DELEGATED HOUSEHOLDER DECISION

Item No.	Report of the Head of Development Management and Building Control	
Address:	DOWNSIDE KEWFERRY DRIVE NORTHWOOD	
Development:	Erection of part single storey, part double storey side and rear extensions following demolition of existing detached garage, conversion of roof space into habitable use to include 1 x rear dormer, 2 x rear facing roof lights, and 2 x front facing dormer windows, and amendments to fenestration and new porch structure together with associated excavation to create a rear outdoor patio.	
LBH Ref Nos:	2025/APP/2024/2399	
Drawing Nos:	24199-24-03 6193-PL001 - Rev F 6193- PL010 - Rev F 6193- PL011 - Rev F Site Location Plan 24199-24-02 6193PL012 - Long section	
Date Plans received:	05-09-24	Date(s) of Amendments(s):
Date Application valid	30-09-24

Front Elevation

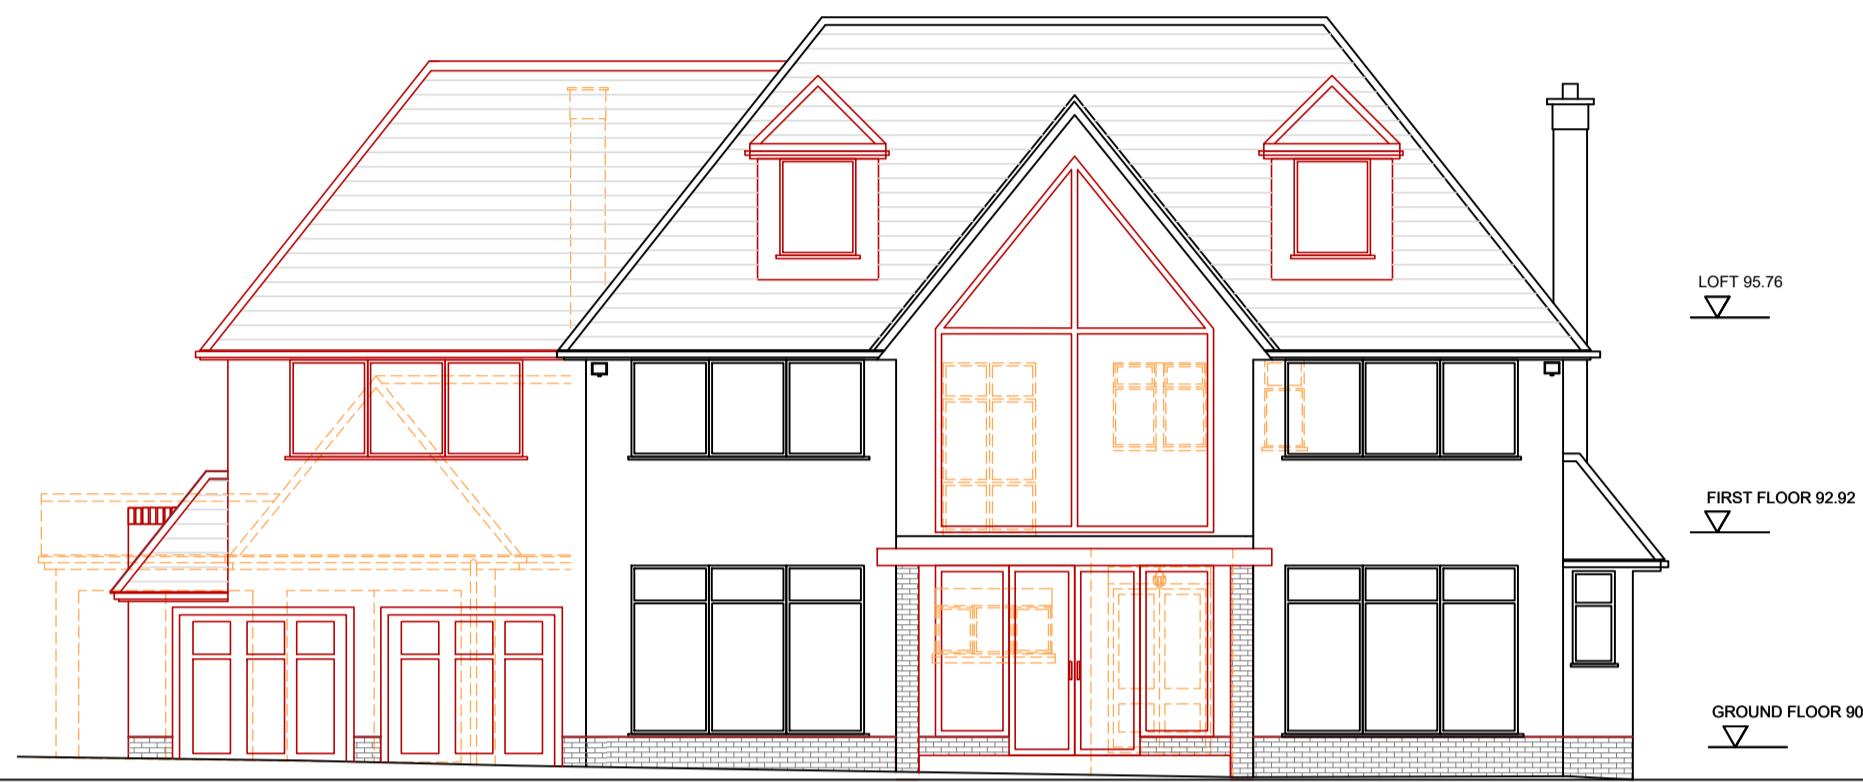
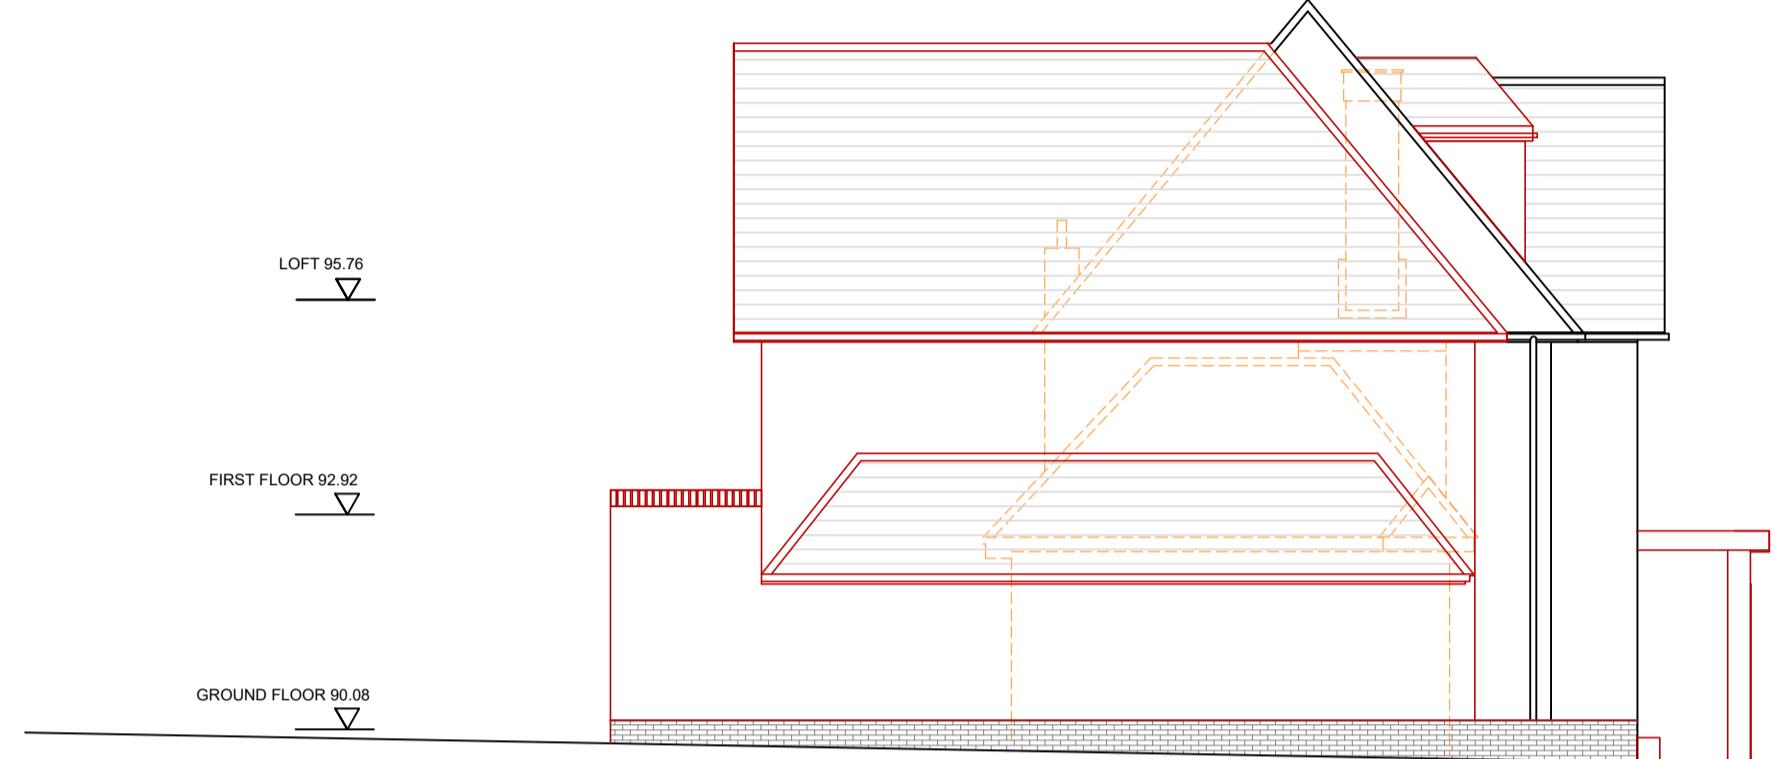
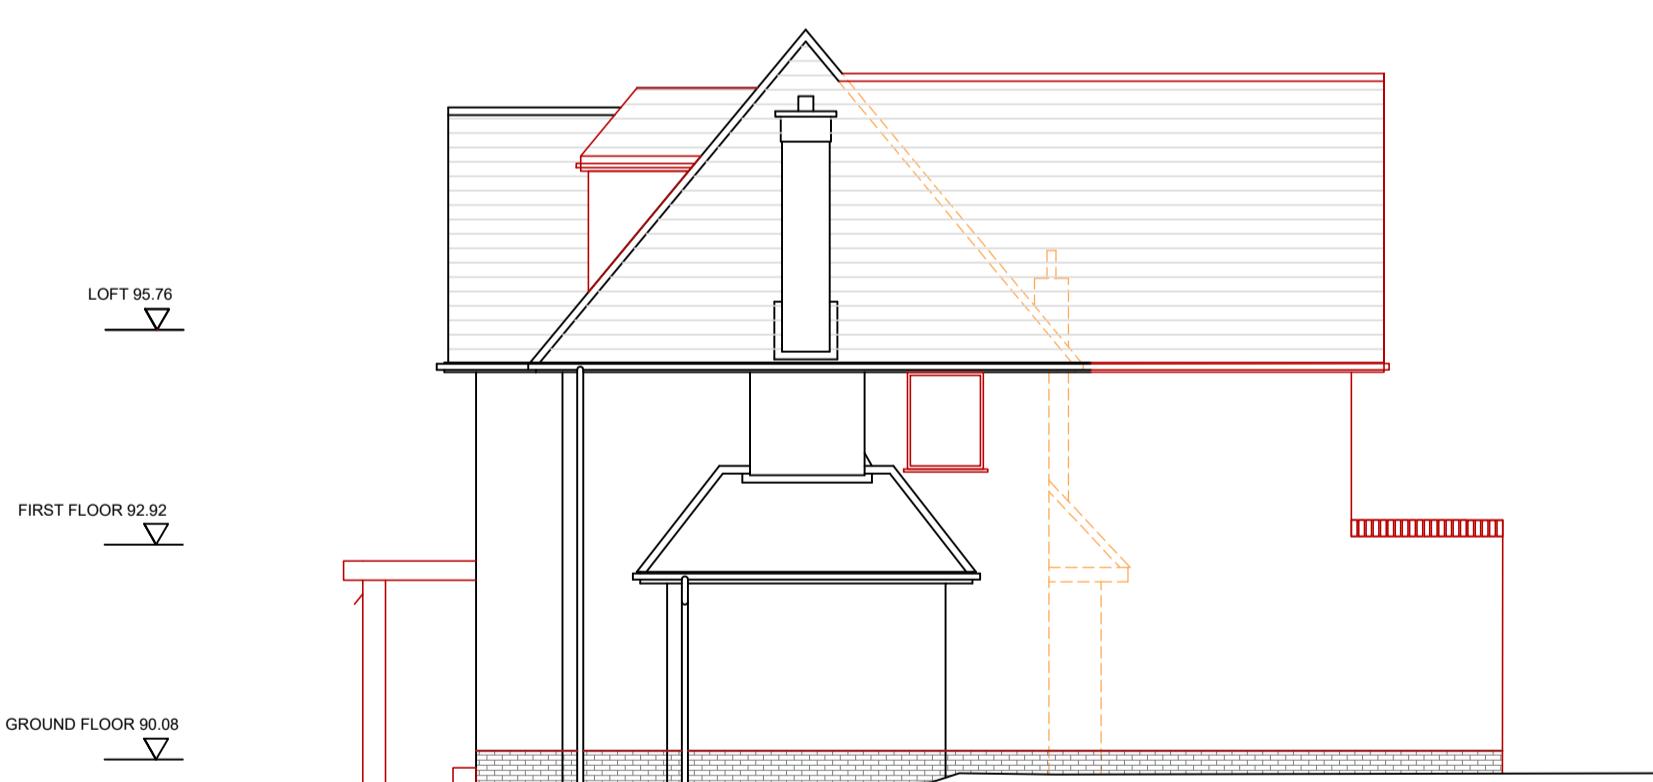
- 1.Redesign of the exterior of the building.
- 2.Set back of the side extension from the front elevation by a 1m

- The street has no consistency in design however, the proposed scheme required amendments to the front elevation as well as a set back to ensure that the scheme is more in line with Policy and so that the front elevation appears more flush.
- Concerns were raised with regards to the patio and its impact on the T1 Willow tree by the tree officers.

These amendments were requested and the applicant sent amended plans 16.12.2024 which addressed the concerns raised. Upon receiving these, in a meeting with the Urban Design team was held 20.12.2024, and they were happy with the proposed scheme. Amendments to the report which addressed the officers concerns about T1 willow and the patio were requested. An updated report was received 04.02.2025 which concluded that there the Willow T1 would not be impacted by the Patio expansion which would warrant a refusal and therefore, the proposed works are acceptable.
